Address: 12, Temple Street, Huddersfield, HD3 3JG

Application number: 2026/92450	
What is the application for?:	Demolition of existing workshop and erection of detached dwelling
Address of the site or building:	Workshop between, 12 & 14/16, Temple Street, Lindley, Huddersfield, HD3 3JG
Postcode:	HD4 6HF

- Materials
- ① Reclaimed natural walling stone.
 - ② Through coloured rendered wall finish.
 - ③ Blue slate roof.
 - ④ Grey windows with natural stone heads, cills and mullions.
 - ⑤ Grey doors.
 - ⑥ Black rain water goods.
 - ⑦ Grey framed rooflights.
 - ⑧ Inset Solar Panel.

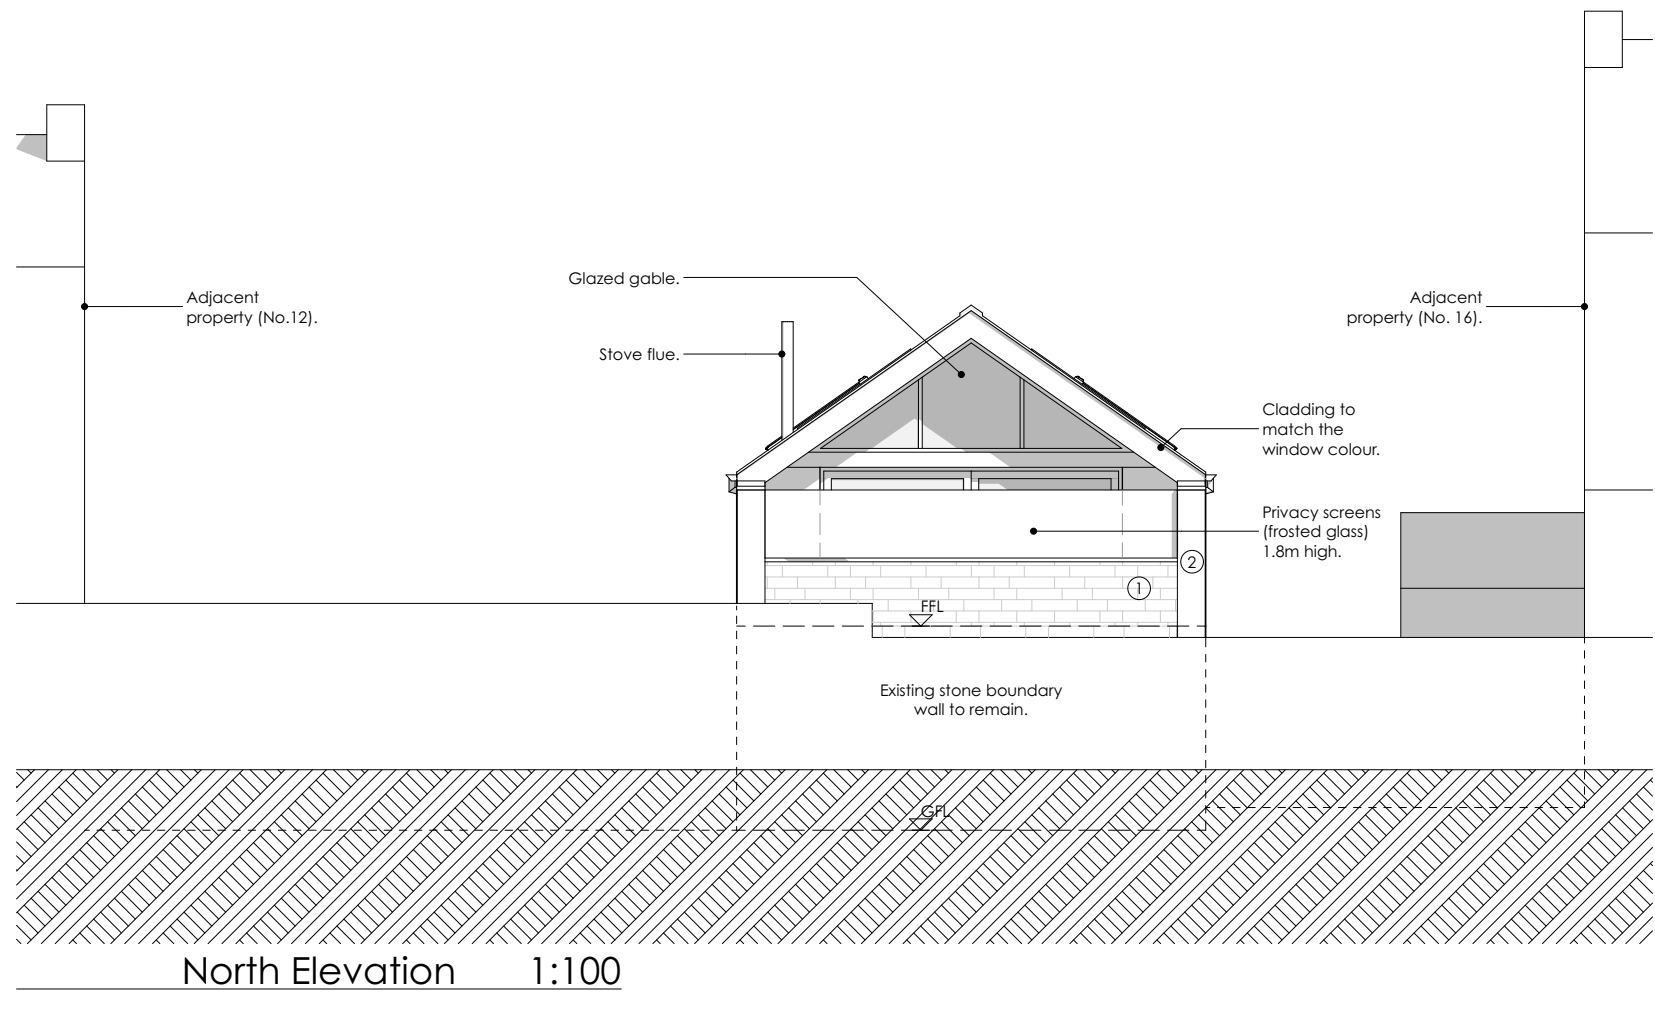
Type of comment: An objection	
Do you wish your comments to be published on the website anonymously?	No
To the windows on the east elevation, as these windows open onto our garden area. It will limit our plans on what we can do with that area of garden. For example if we want to move the garage backwards or build a summer house. Also concerned as this will be a bedroom it will impact how we can social use the space.
